**Application by SP Manweb for an Order Granting Development Consent for the Reinforcement to the North Shropshire Electricity Distribution Network**

**Canal & River Trust Response additional submission for deadline two**

**Written question from examining authority – Q9.0.1**

KEY

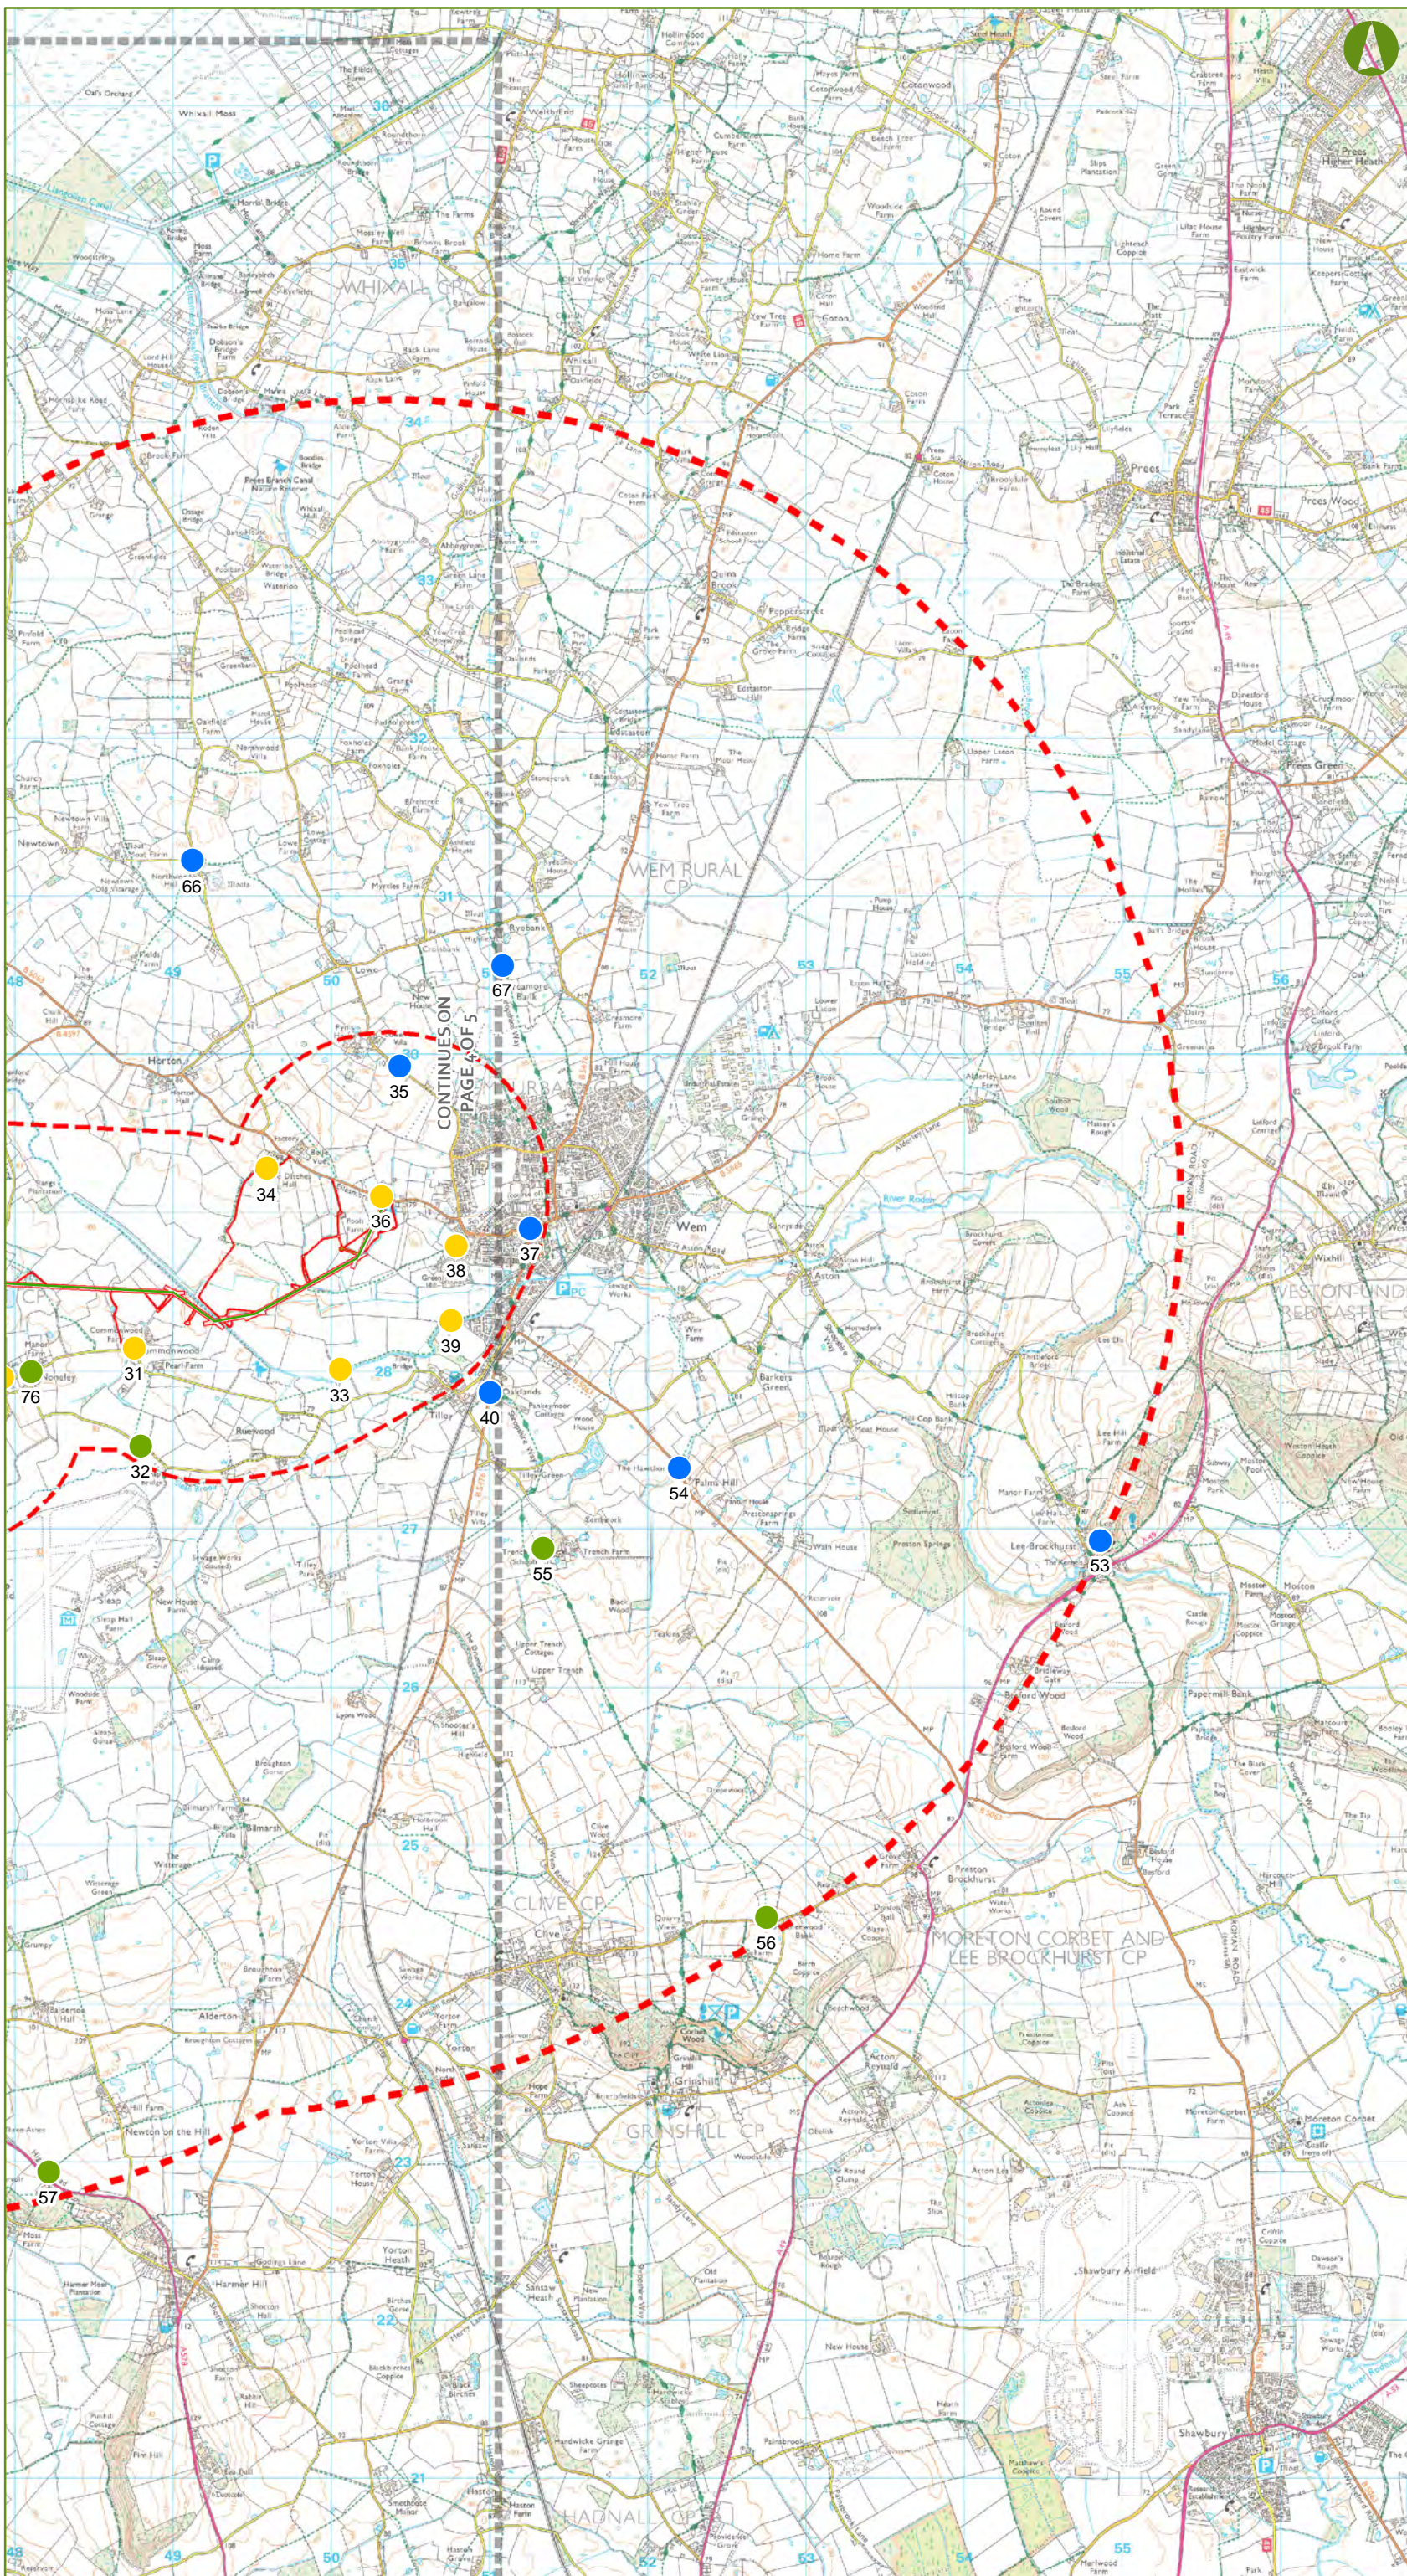
The LVIA document itself is relatively generic and sets out the methodology for assessing impacts. We consider that the methodology used is appropriate. We generally agree the findings of the LVIA in terms of the impact on the canal, insofar that it assesses the overhead line at viewpoints 8, 9 and 10 and assesses the impact from these points as being of 'minor significance'. However, the Trust are unable to agree to the findings of the LVIA in totality, as we would like to see further assessment of the visual impact from underneath the lines where it crosses the canal. As stated at Table A6.3.5 of Appendix 6.3 (page 81), at the point the line oversails the canal the magnitude of change would be medium and effects on visual amenity moderate adverse (i.e significant). We consider that this justifies a further viewpoint/photomontage being provided from underneath the lines where it crosses the canal. This would enable a full assessment of the impact to be undertaken and for the required mitigation to be identified. This in turn may require the viewpoint to be considered amongst the sites assessed at Table 6.4 of the LVIA and conclusions of the LVIA at paragraph 6.9.3.

In the absence of the above viewpoint, the Trust do not agree to paragraph 6.8.2 of the LVIA and the applicants assertion that no mitigation is required. As acknowledged by the applicant, there would be an impact at the point the line crosses the canal, which requires full further assessment to identify whether mitigation is required.
